Application for a Non-Material Amendment Following a Grant of Planning Permission

Number	25
Suffix	
Property Name	
Address Line 1	Riverside Way
Address Line 2	
Address Line 3	Hillingdon
Town/city	Uxbridge
Postcode	UB8 2YF

Installation of roof-mounted solar PV panels, consisting of 51 individual panels (Application under Class J, Part 14, Schedule 2 of the General Permitted Development) (England) Order 2015 (as amended).

Amendment of description of development to reference 33 PV panels rather than 51.

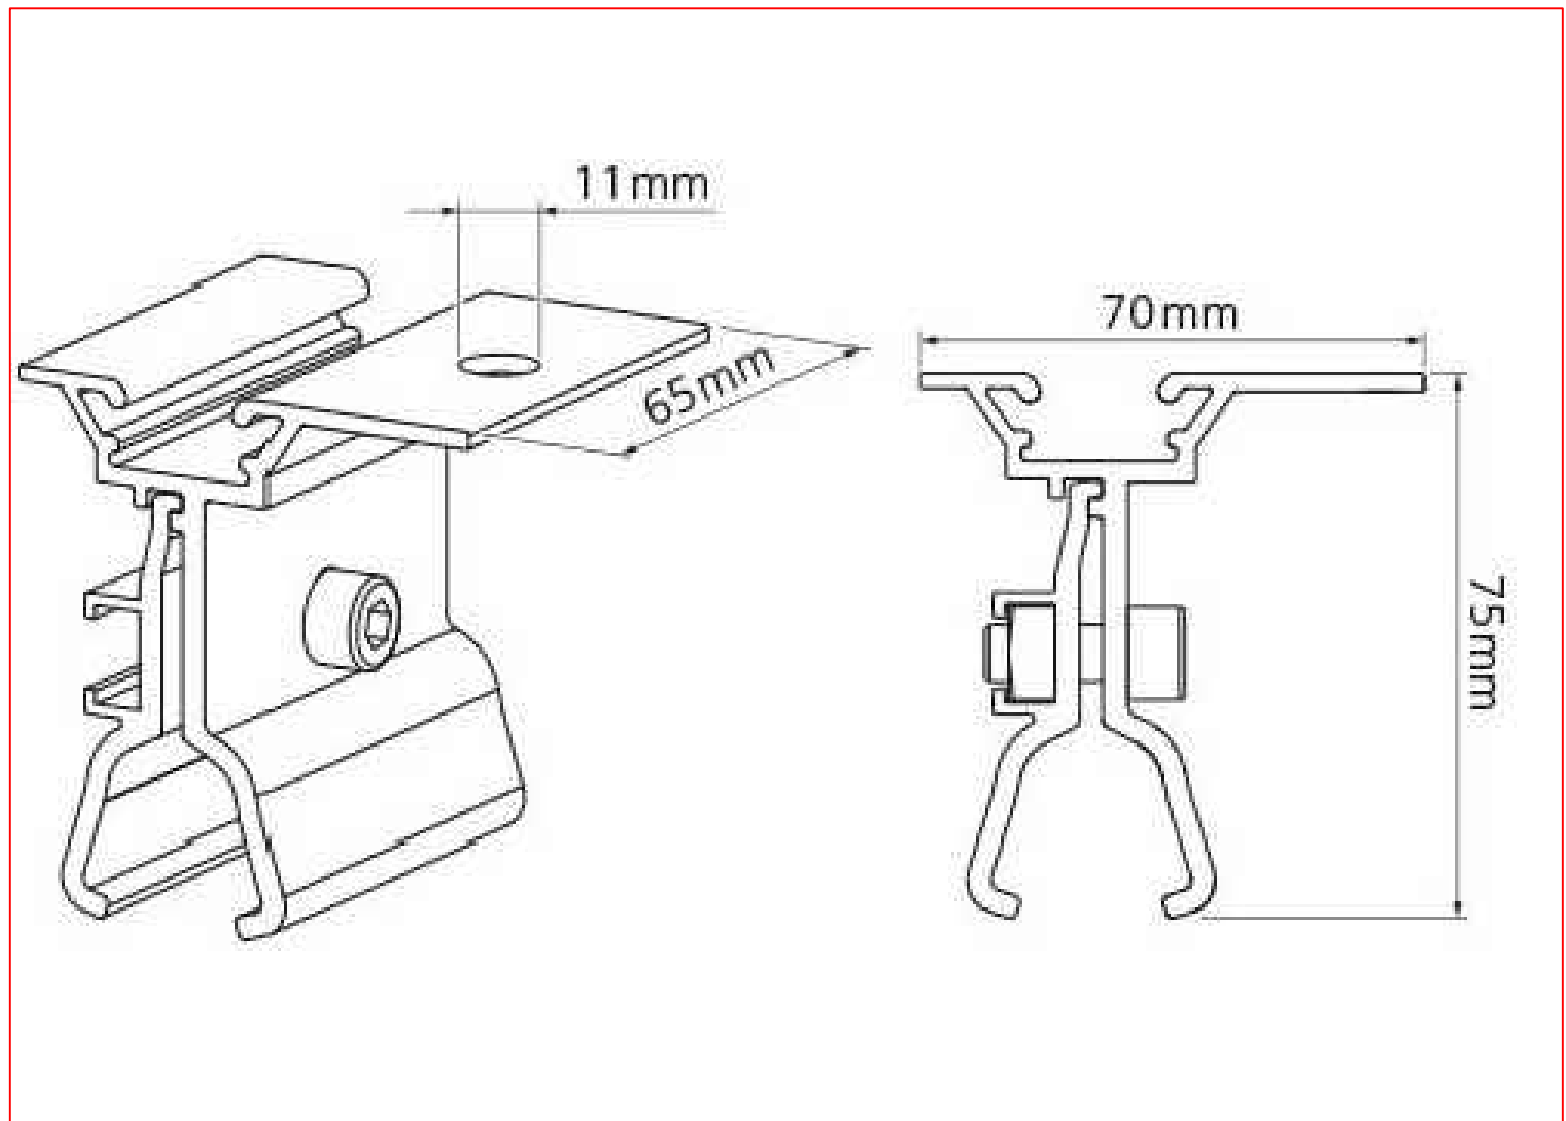
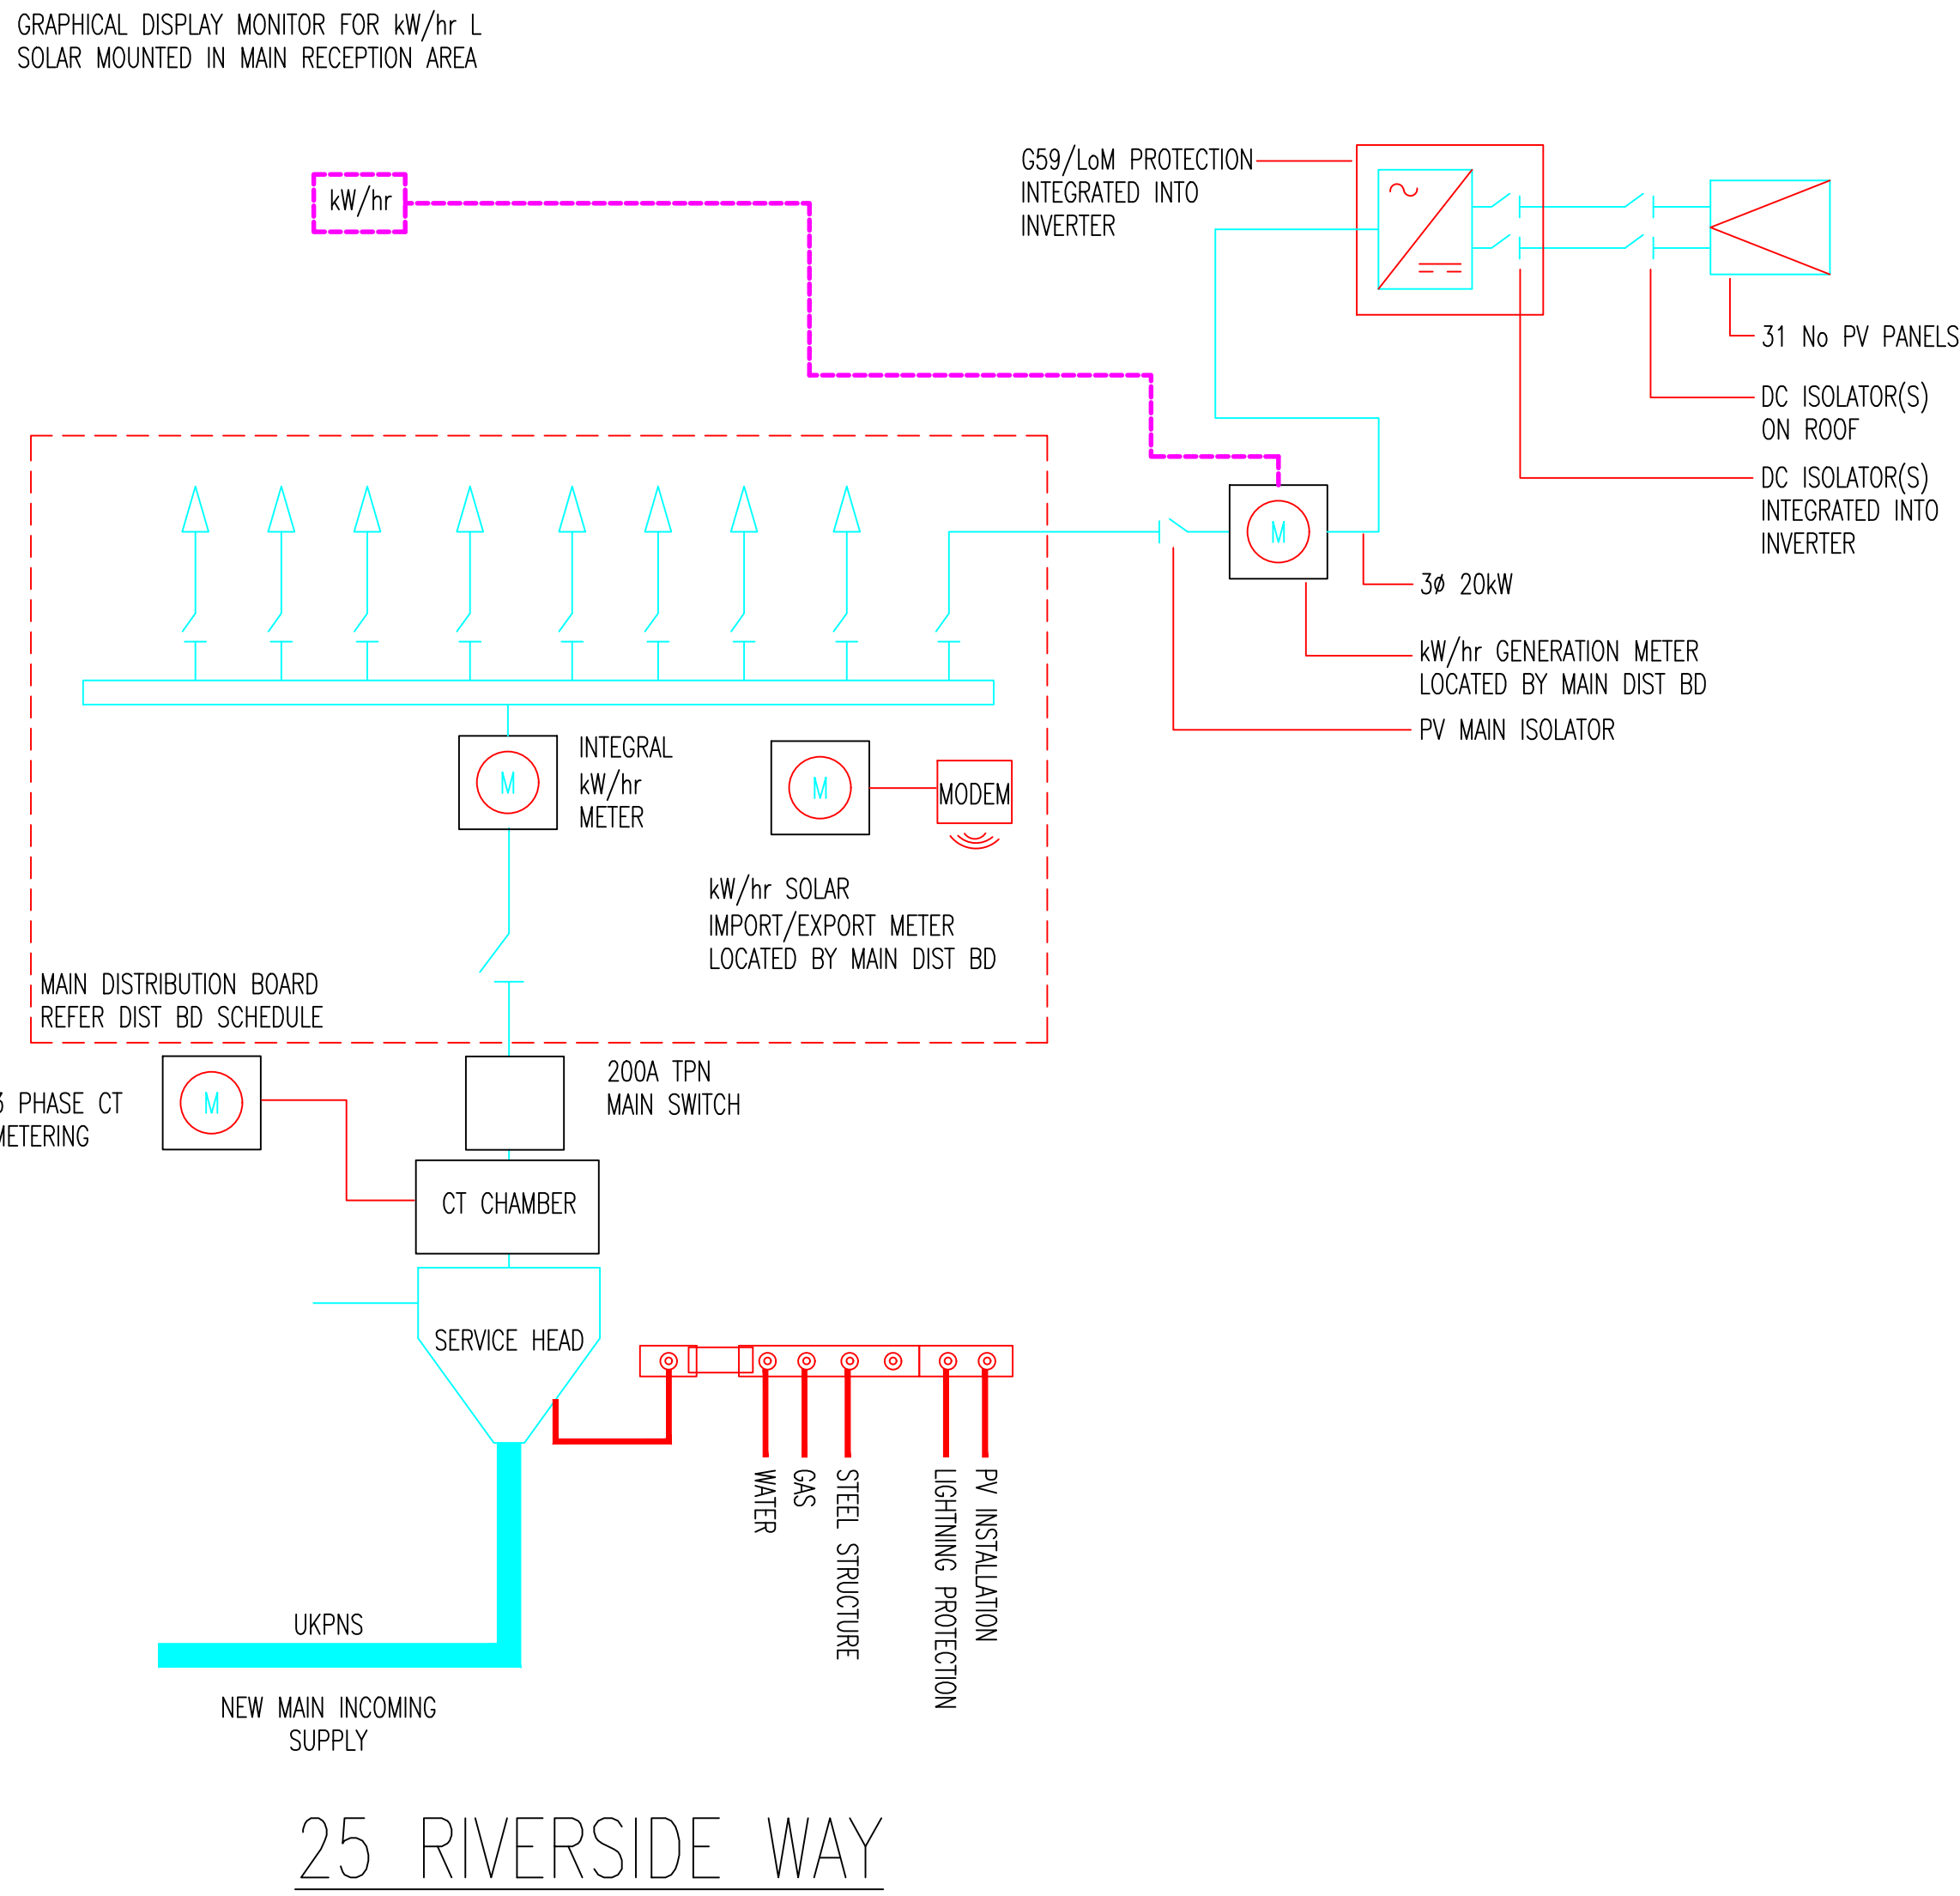
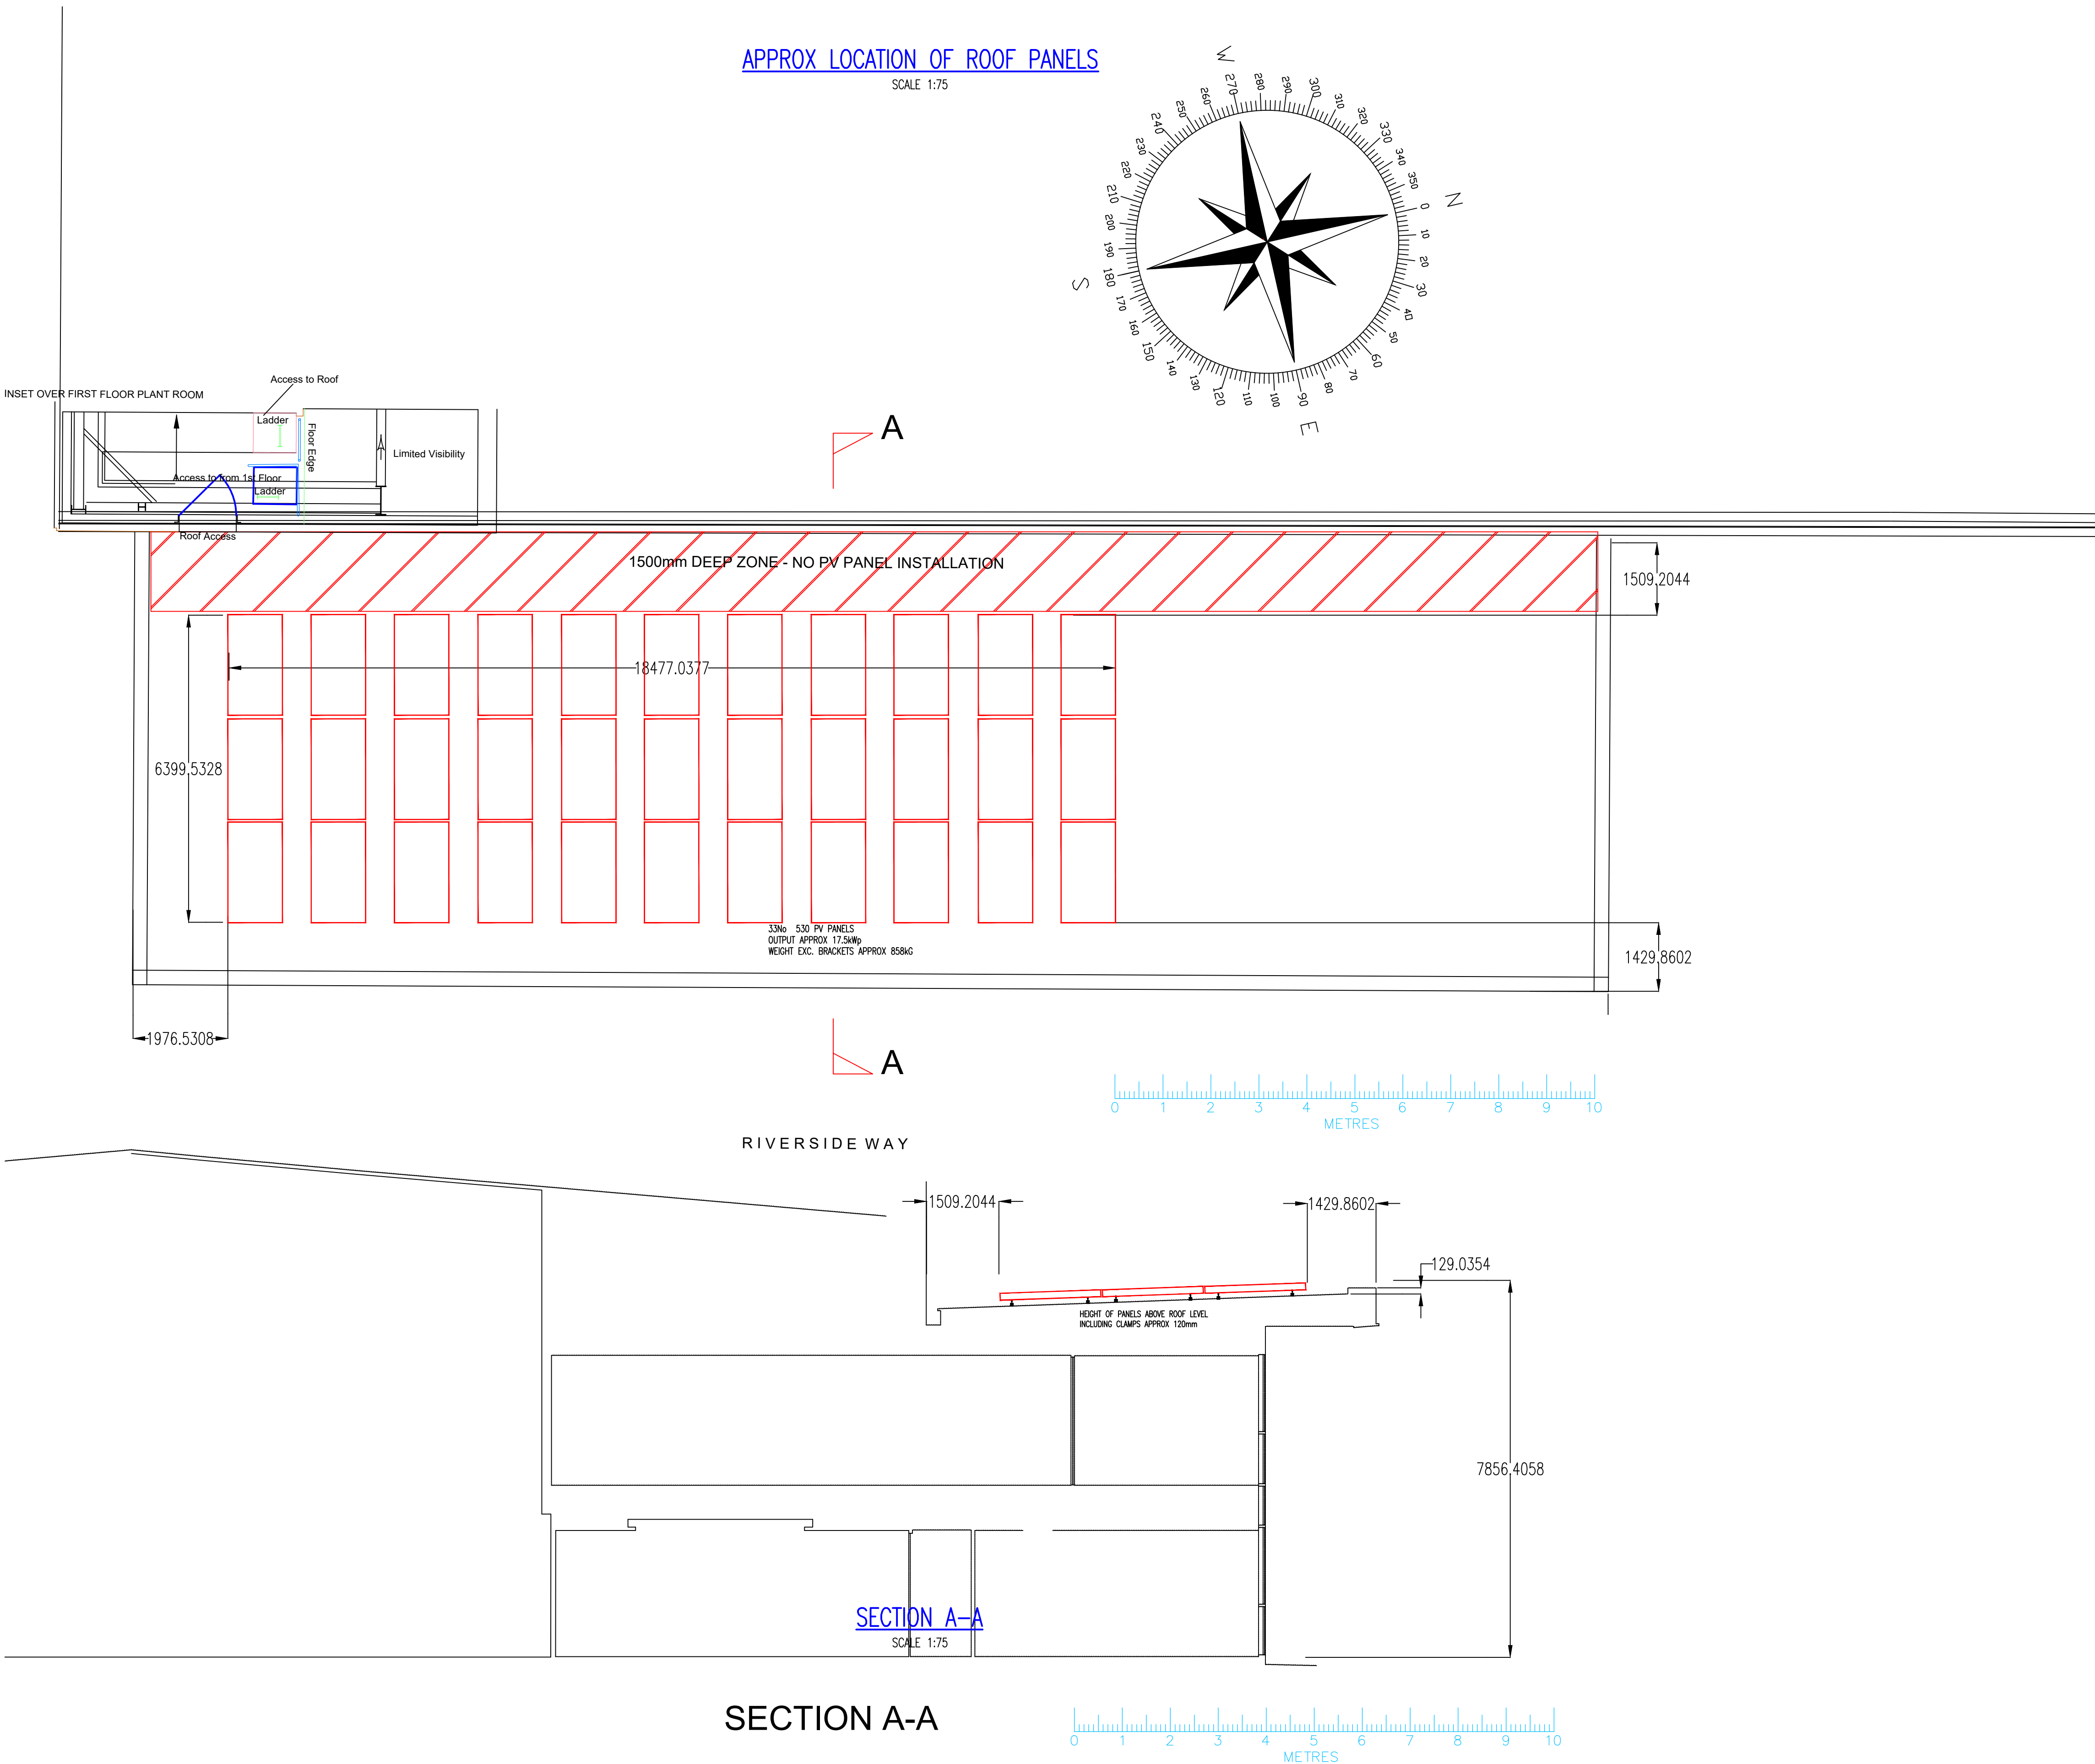
The proposed reduction in the number of panels owes to the selection of a different specification.

3038-E-300 Rev B
